Mandalong Mine Southern Extension Project SSD5144

Submission from Brian Byles PO Box 72 Morisset NSW 2264

Date 08/12/13

Figure 54 – Assumed Location of Construction Noise Sources for Shaft Sinking

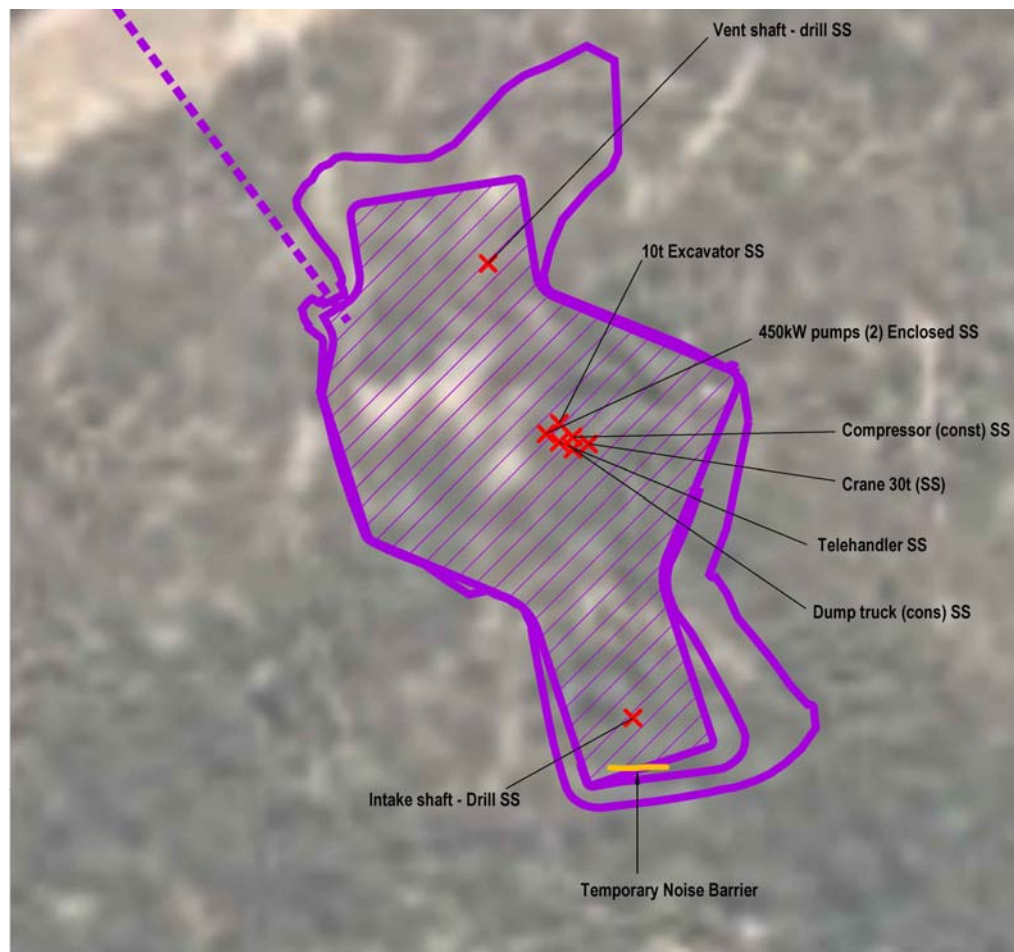
On page 46 of the Noise Impact Assessment, it is stated that "Shaft sinking activity is likely to occur 24 hours per day, seven days per week". This will continue for 78 weeks (Environmental Impact Statement Table 9).

This will create unacceptable noise pollution. 78 weeks is a long time for people to have to put up being deprived of one of their most valued amenities - rural peace and quiet.

It is reasonable to require that the noise generated by shaft sinking should be subject to the same conditions that I have requested for operational noise i.e. that the noise coming from shaft sinking should not be heard in any habitable room of a house.

During the last few years when boreholes were being drilled in Mandalong, I found the most evident noise was from the diesel engines used to drive the drill rig. As shaft sinking will occur after the completion of the access road and site excavation, it should be feasible to then build the Ausgrid 33kv power line so that the drill rig and the two 450kW hydraulic pumps can be driven by electric motors, which are not noisy.

Figure 56 – Assumed Location of Operation Noise Sources at Mandalong South Surface Site

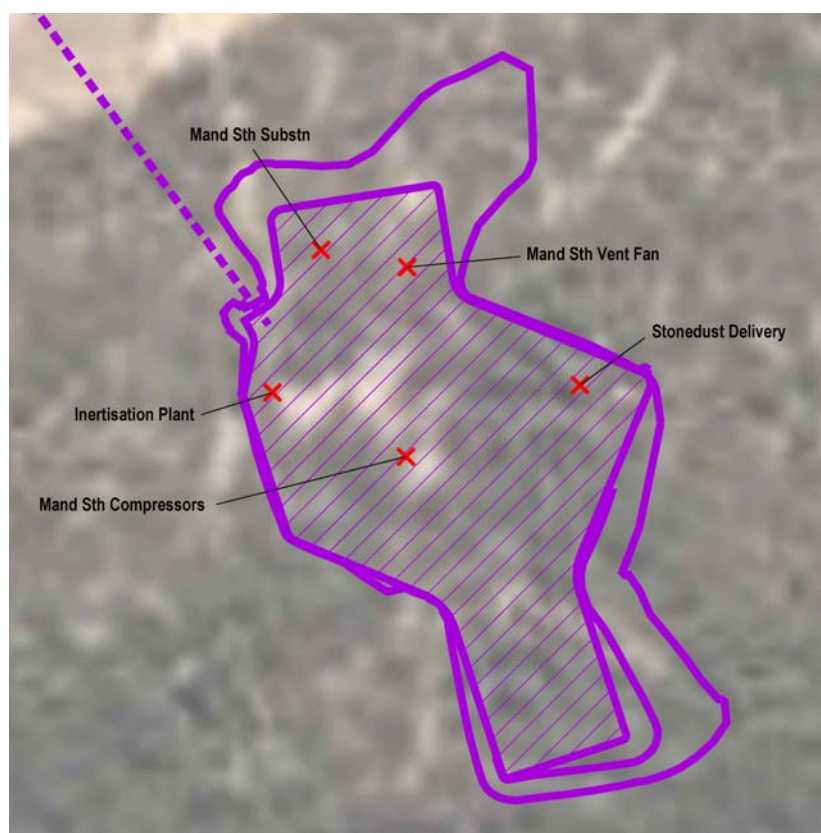
Noise Impact Assessment Figure 3 - Proposed Mandalong South Surface Site Layout shows a small rectangle labelled 'Gen set'. Is this an emergency generator? If so, it should be included in the noise assessment. It would have to be run at regular intervals for testing purposes.

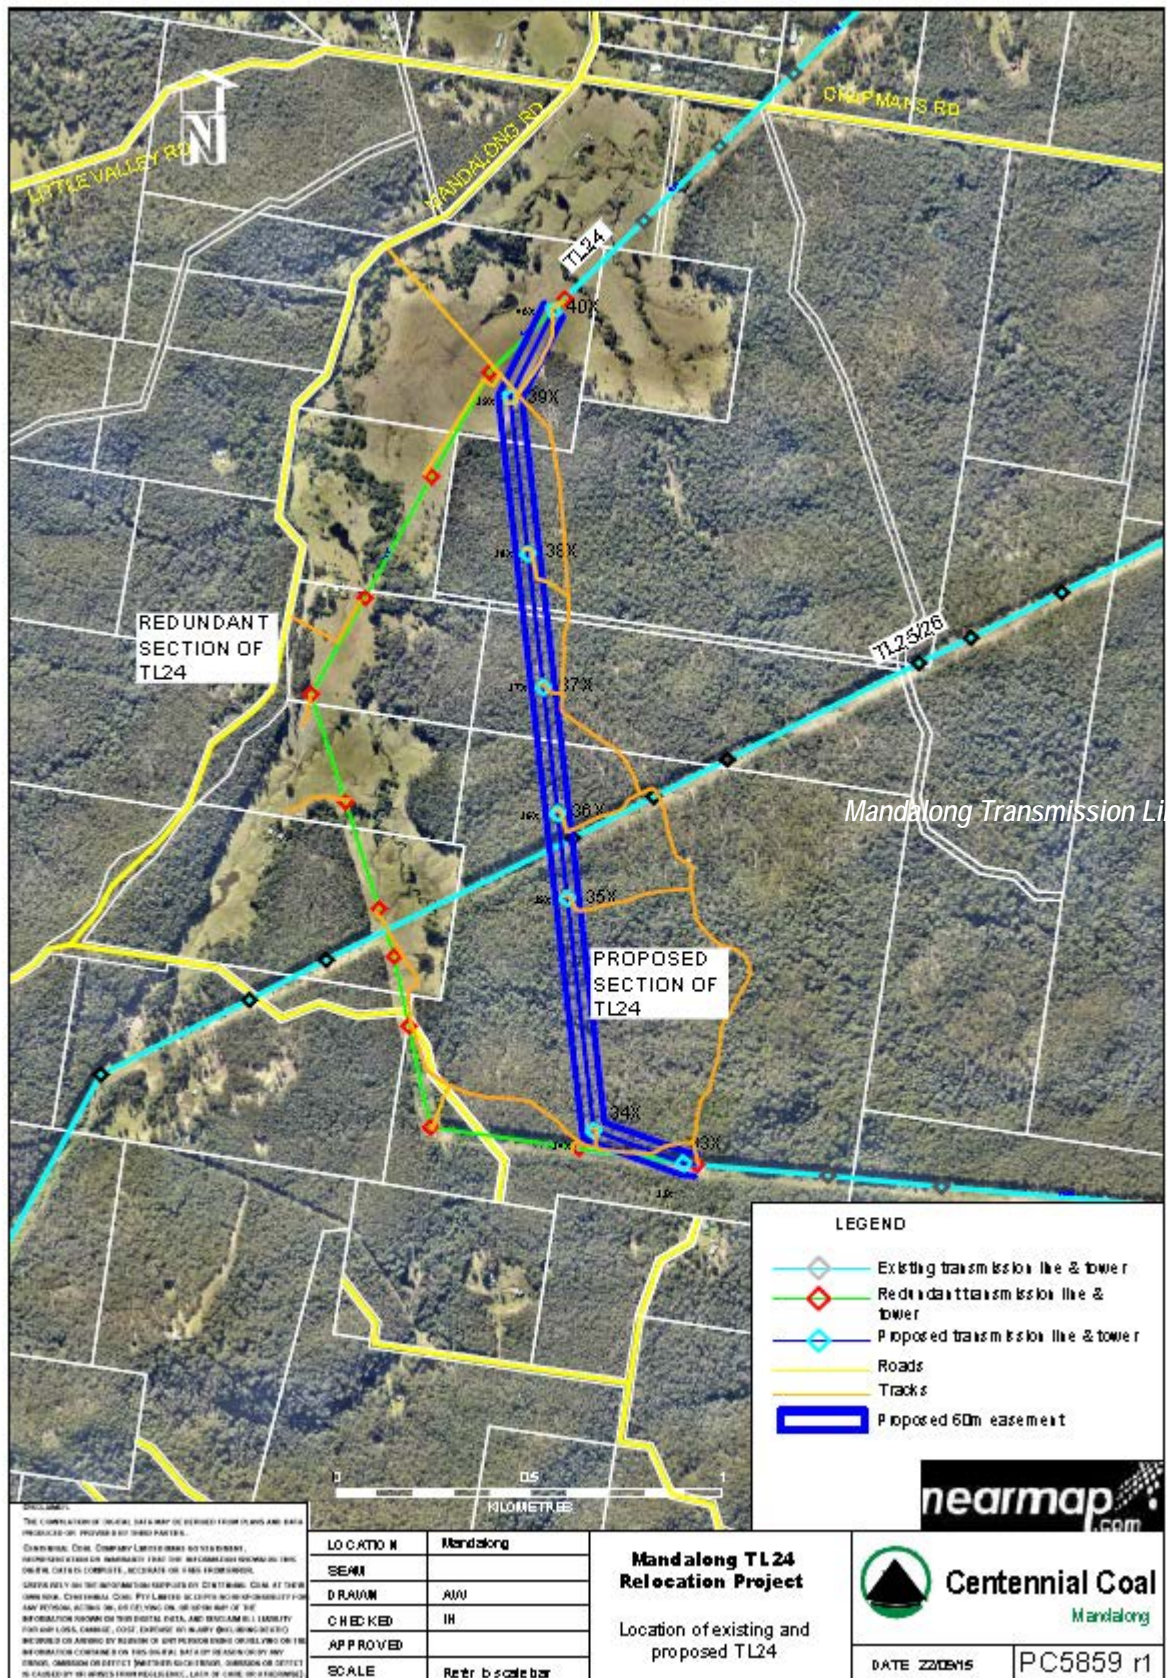
The Flora and Fauna Assessment does not take into account the impact on the environment of the relocation of power line TL24. During a community information session, we were informed by members of the project team that, in order to make the project viable, a section of TL24 had to be relocated because some towers would require uneconomical modification to compensate for subsidence.

Statements indicating that this is being considered are made in several different places in the EIS. For example: Appendix M - Subsidence Predictions and General Impact Assessment, Page 135 states: "Five tension towers along TL 24 are currently within the proposed limits of the longwall extraction with two towers inside a 26.50 angle of draw from the panel limits (no.s 27 and 28). These towers are likely to be subjected to cumulative tensile or compressive strains in excess of 1 mm/m. *It is understood that these towers will be relocated prior to mining impacts.*"

If the transmission is relocated, then parts, if not all, of the new easement would be cleared to meet the Transgrid standard. The area involved is estimated at at least 10 hectares. New tower access roads would be required. Any route selected for the relocated line would intersect hills and steep gullies. This country is mainly covered by undisturbed native vegetation. As the size of this land is comparable to that of the proposed Service Site, it is reasonable that the impact of both should be assessed concurrently.

I request that the EIS for the relocation of TL24 be prepared and put on exhibition and assessed in conjunction with the mine Extension Project.

As stated above, the Project Team have indicated that, for this project to be viable, sections of the transmission line TL24 will have to be relocated.

Regardless of the route selected, the 60 metre wide easement for this 330kv line would traverse the ridge that is east of Morans Creek. A tower would be on the top of the ridge which would make it visible from Mandalong Road. This area is covered with native vegetation and appears as an attractive natural skyline. There would be an adverse visual impact if the power line was relocated. The soil on this ridge is thought to be susceptible to tunnel erosion which could develop if the trees were removed.
